Application Ref:	3/2025/0960	 Ribble Valley Borough Council www.ribblevalley.gov.uk
Date Inspected:	02/01/2026	
Officer:	KH	
DELEGATED ITEM FILE REPORT:		REFUSAL

Development Description:	Variation of conditions 01 (approved plans) and 2 (external facing materials) from planning permission 3/2023/0118 to allow regularisation of as-built amendments to approved plans.
Site Address/Location:	8 Hammond Drive Read BB12 7RE

Drawing Title
Proposed Elevations

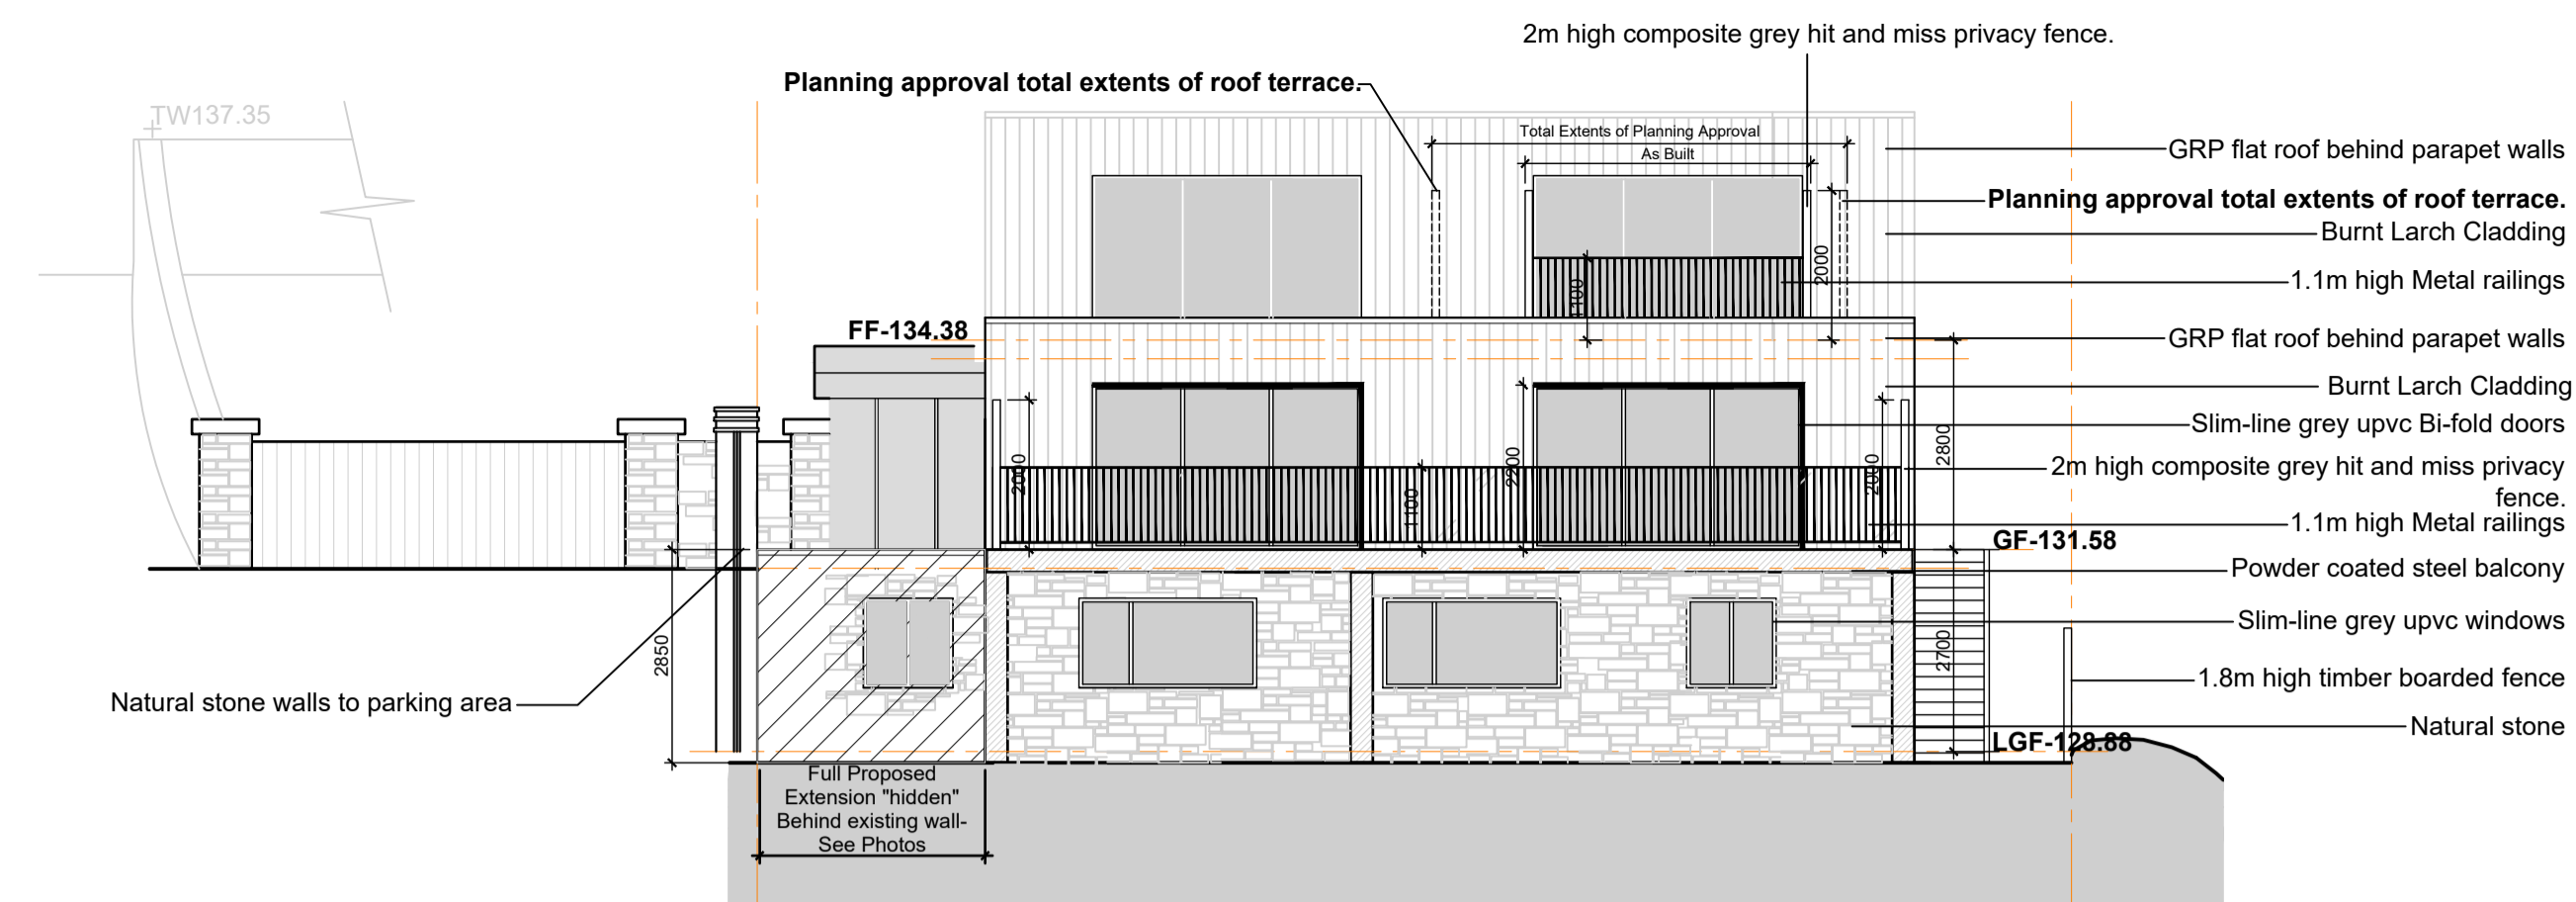
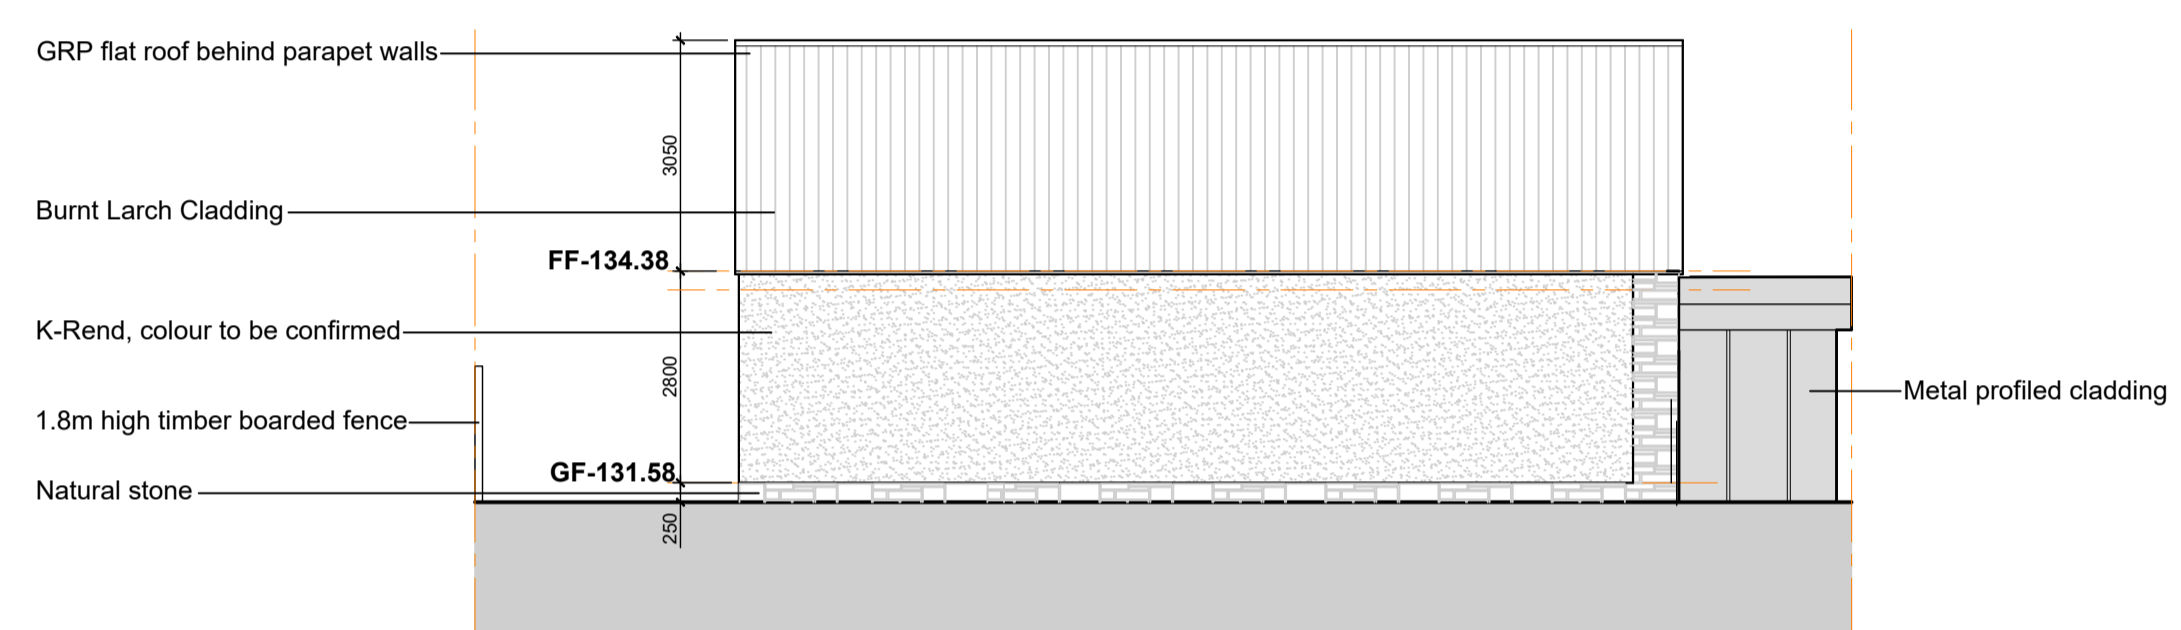
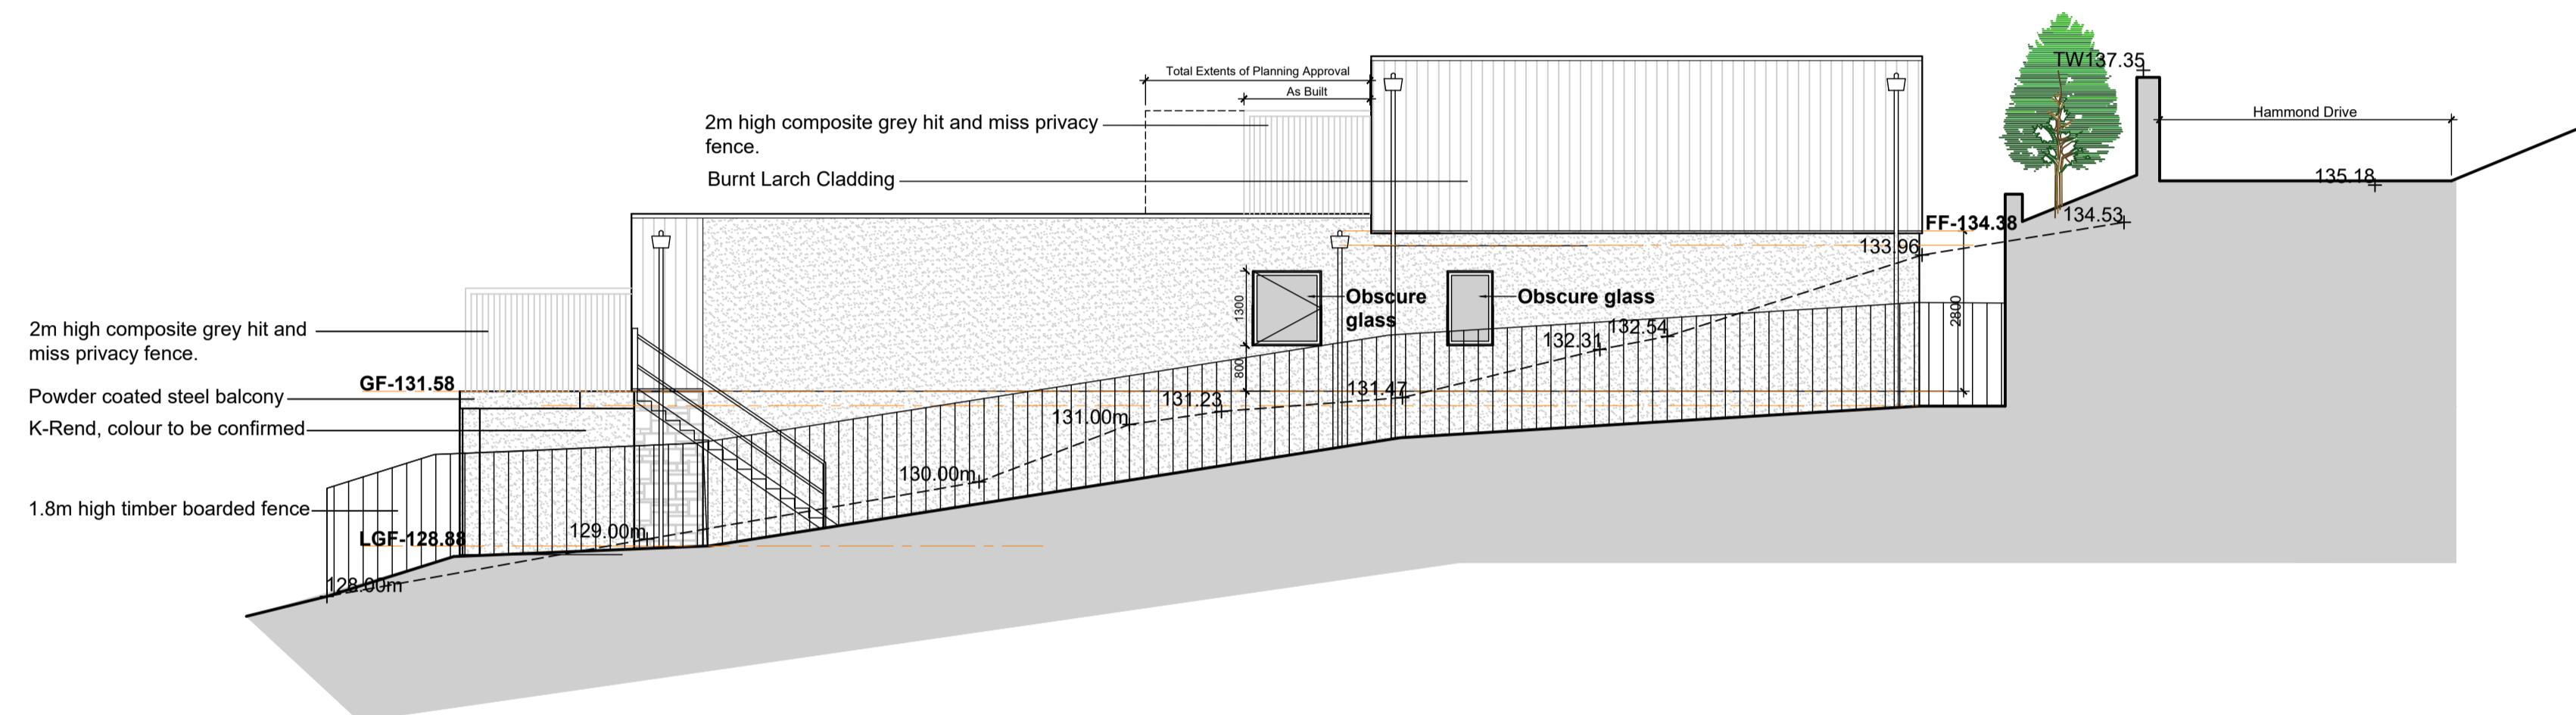
The reason for varying condition 1 is due to the fact that the proposal has not been built in accordance with the approved plans with regard the privacy screens approved under application 23/0118 to be erected to the first and ground floor balcony elements. This application seeks to regularise the works which consists of 2m high composite grey hit and miss fencing.

The reason for varying condition 2 is due to the privacy screen materials which have been changed from glass balustrade / opaque glazing to composite fencing as set out above.

The fencing which has been erected is not appropriate in terms of the materials and, by its design, also allows for views into adjacent properties which negates the requirement for the privacy screening to the balconies. The fact that the 2nd floor balcony has been reduced in terms of width and projection does not outweigh this harm. The hit and miss fencing has been poorly constructed on site leading to concerns over its effectiveness and loss of privacy. Nonetheless it is considered that even with better quality materials and appropriately fitted fencing the change is materials is not acceptable.

The glazed balustrade to the frontage of the balconies has been replaced with 1.1m metal railings which is acceptable in this instance.

It is recommended that conditions 1 and 2 are not varied as the amended materials result in an unacceptable impact to neighbouring property Robin Hill by virtue of loss of privacy.

Additionally the approved design was for a more light-weight structure to enclose the balcony, whereas the as-built structure represents a poor-quality design and unsuitable materials. Concerns are raised above about the construction of the fencing on site. Nonetheless it is considered that even with better quality materials and appropriately fitted fencing the change is materials is not acceptable.

The proposed variations to conditions 1 and 2 would result in unacceptable impacts on the neighbouring property Robin Hill in terms of loss of privacy. Additionally, the proposed materials are considered to represent poor design. This is contrary to Policy DMG1 of the Ribble Valley Core Strategy.
